Addendum No. 1

RE: Contract # C204738

McDowell County (HI-0010)

I-40 FROM MILEMARKER 67 TO MILEMARKER 73 (OLD FORT MOUNTAIN).

**SINGLE SLOPE  
CONCRETE BARRIER**

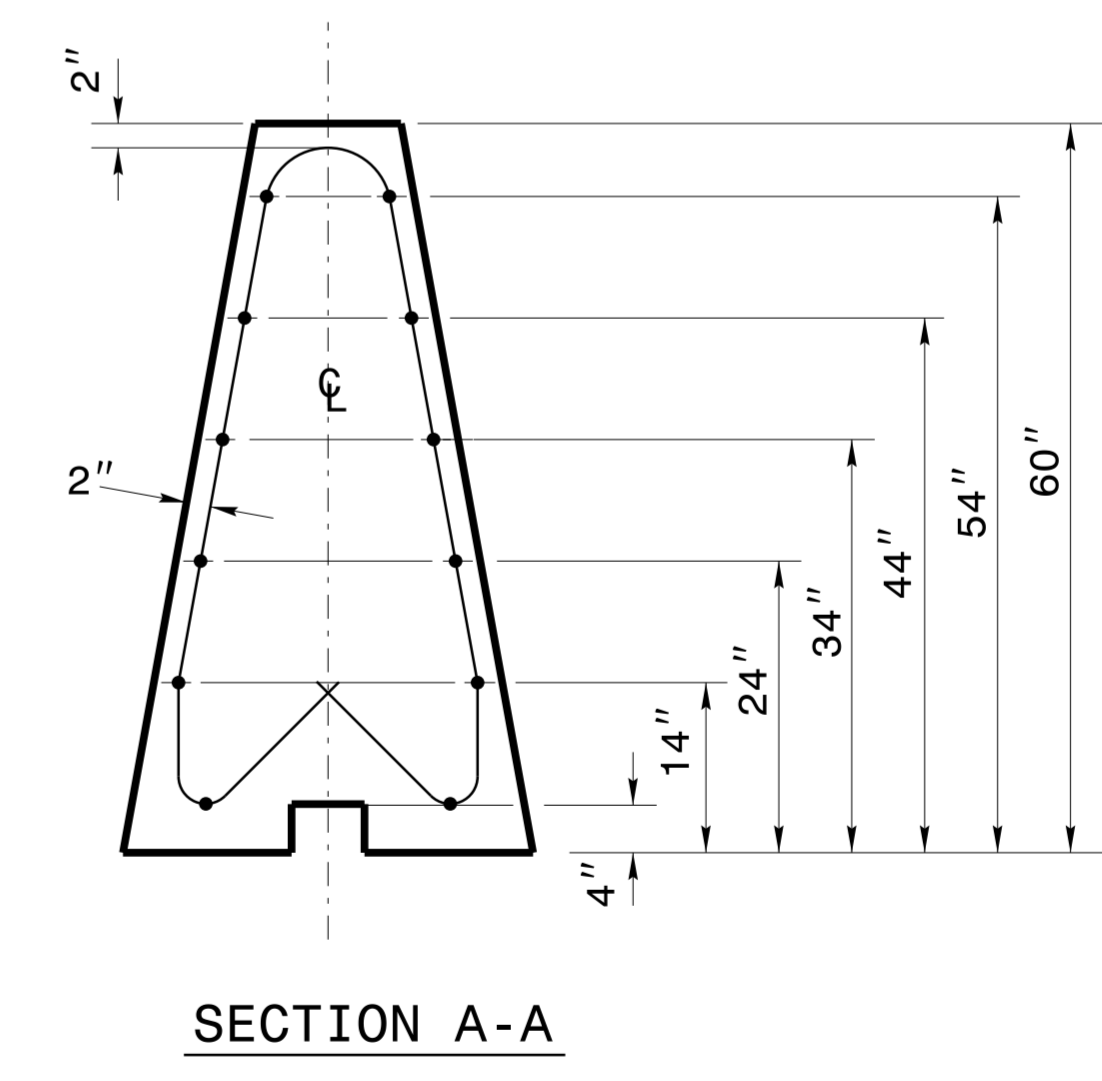
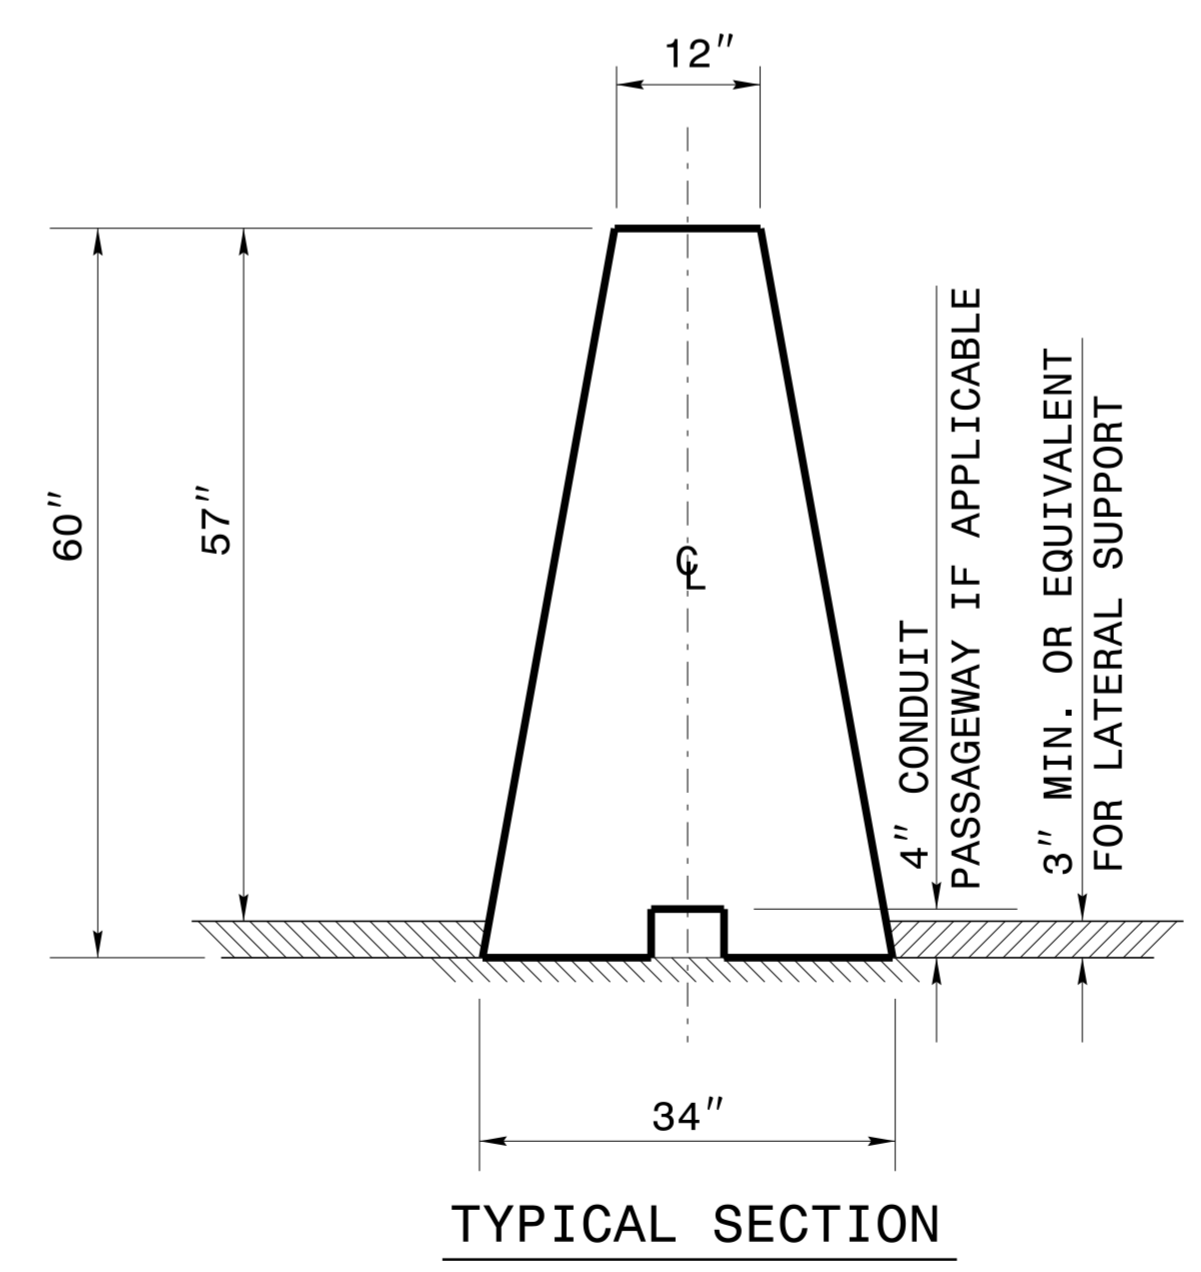
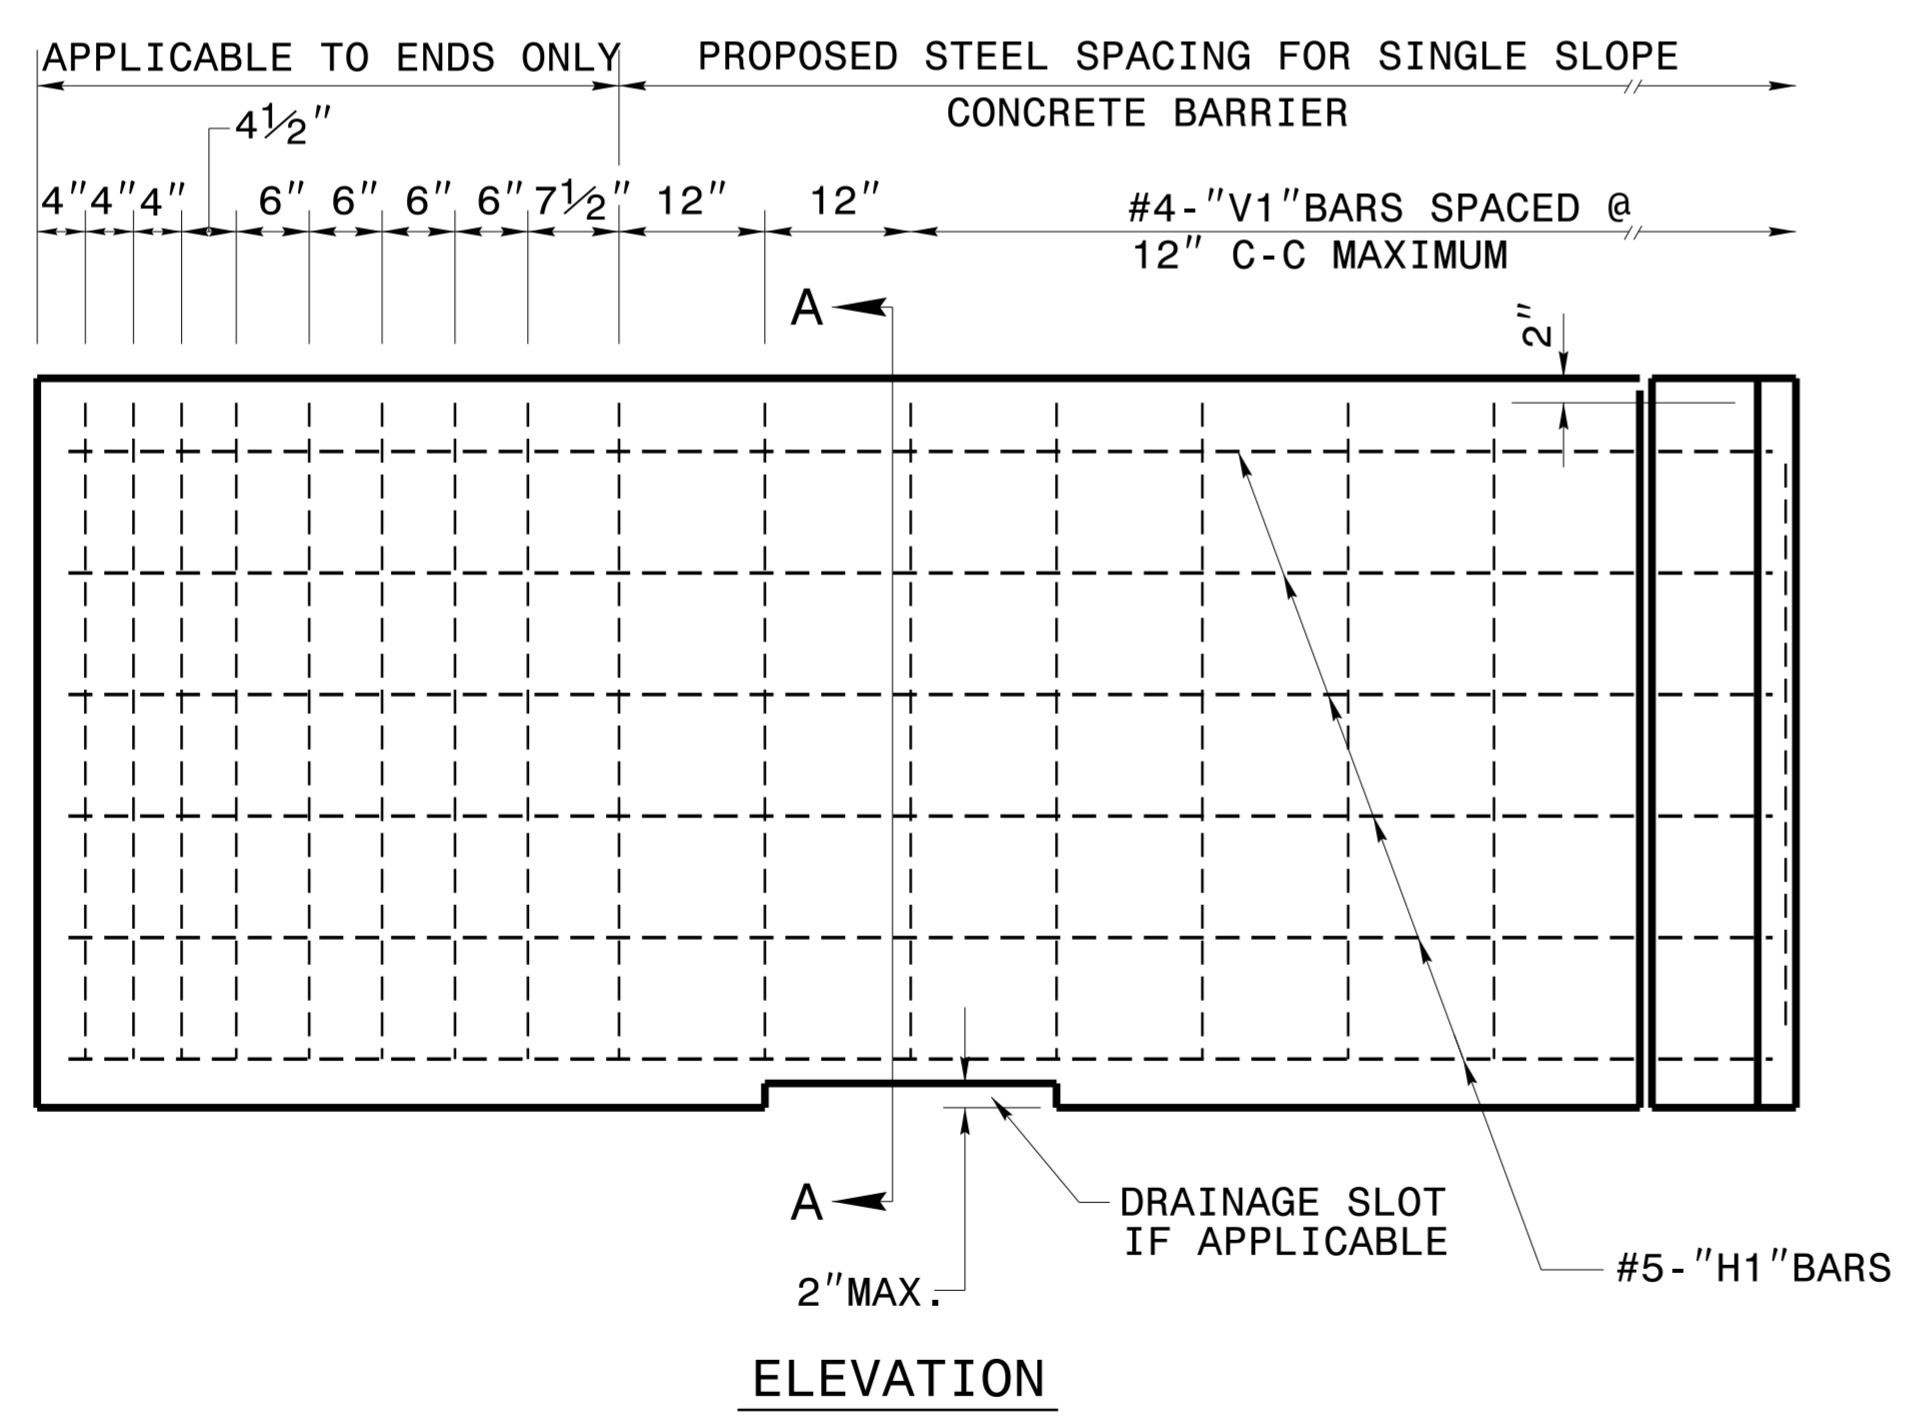
Sheet No.	Revision
2A-1	Two notes added in lower right-hand corner.
2C-6 (New)	Single Slope Concrete Barrier detail plan sheet added.
